SUBSURFACE WASTEWATER DISPOSAL SYSTEM APPLICATION

JENNIFER SANBORN
REPLACEMENT SYSTEM VARIANCE REQUEST

System's Location: 380 Pleasant Avenue, Peaks Island

SUBJECT: Approval, Replacement System Variance Request, Axiotis property, Peaks Island

SITE PLAN Scale 1" = 40 ft.

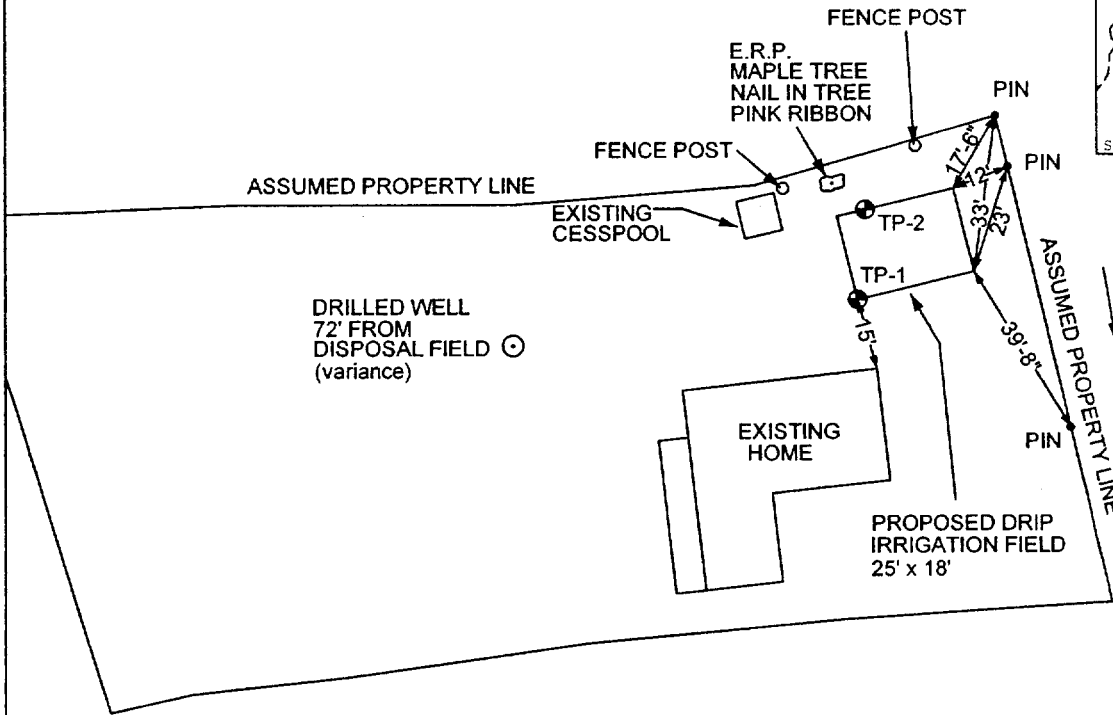
Comments: No PRACTICAL LOCATION FOR TANK

SUBSURFACE WASTEWATER DISPOSAL PLAN

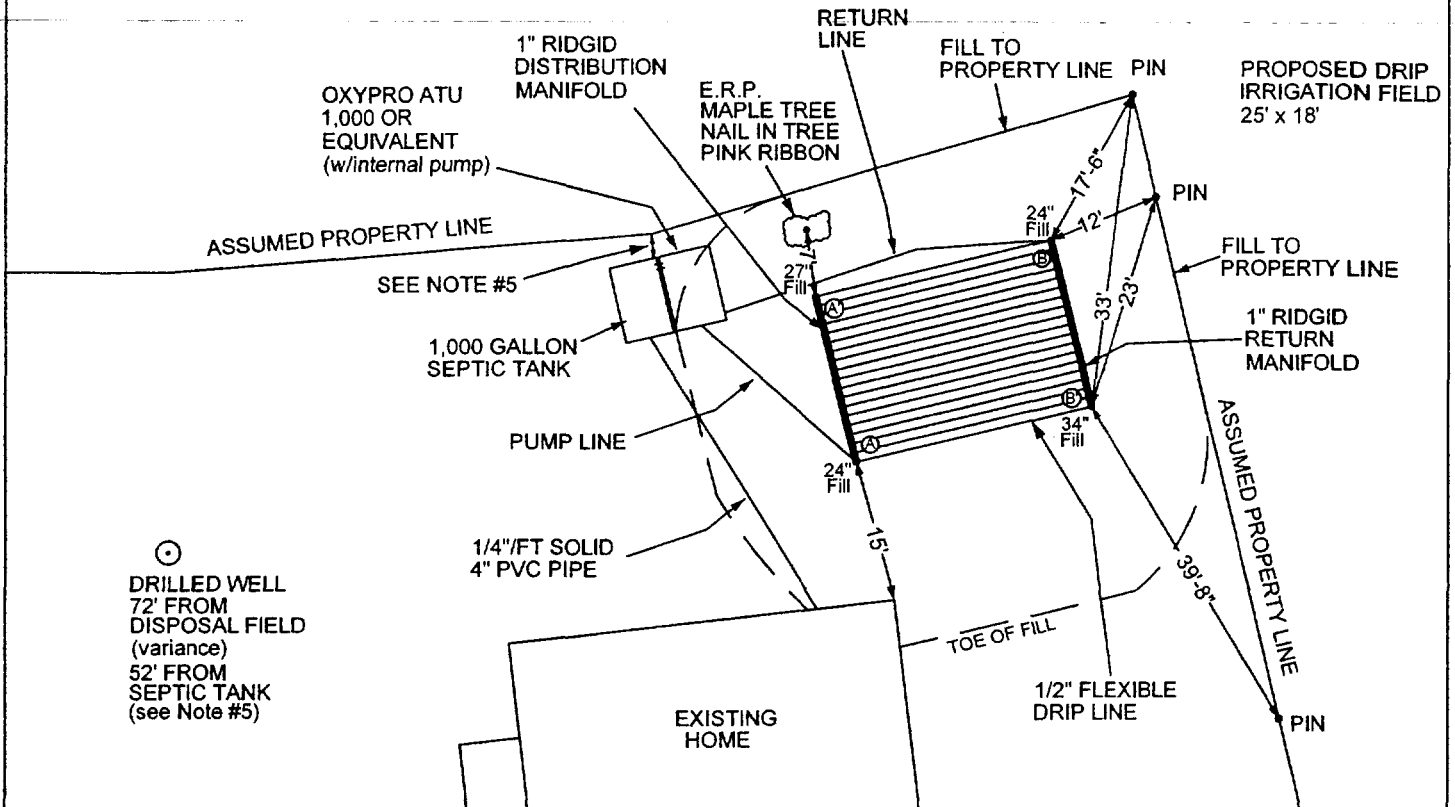
The Division has reviewed a replacement system variance request for the subject property. The state variance requested is to install the system with a setback distance reduction from your well to the disposal field of 72 feet, a setback distance reduction from a slab, frost wall, or columns to the disposal field of 14 feet, a setback distance reduction from a property line to the septic tank of 0 feet, a reduction in depth to the seasonal high ground water table from 12 inches to 0 inches, a reduction in depth to bedrock from 24 inches to 1 inch, and a fill extension grade to 3:1 as needed to keep fill from crossing the property lines. As we understand the situation, the variance request has been submitted because topography and existing development limit the potential system location. The system design prepared by Andrew Gobeil, SE, dated 09/18/2005 is otherwise found to be in compliance with the Maine Subsurface Wastewater Disposal Rules.

We approve the requested variance with the following requirements:

1. A permit for system installation is to be obtained from the Local Plumbing Inspector in advance of the start of system construction.
2. The system is to be installed in accordance with the submitted and approved system design. Should alterations to the design be required at the time of construction, the site evaluator is to be notified prior to making any changes.
3. The contractor is to scarify the soils under the fill extensions to create a transitional zone more compatible with the disposal field area.
4. The septic tank to be installed shall be monolithic.
5. No fill shall cross over the property lines unless a legal easement is granted by the abutting property owners.
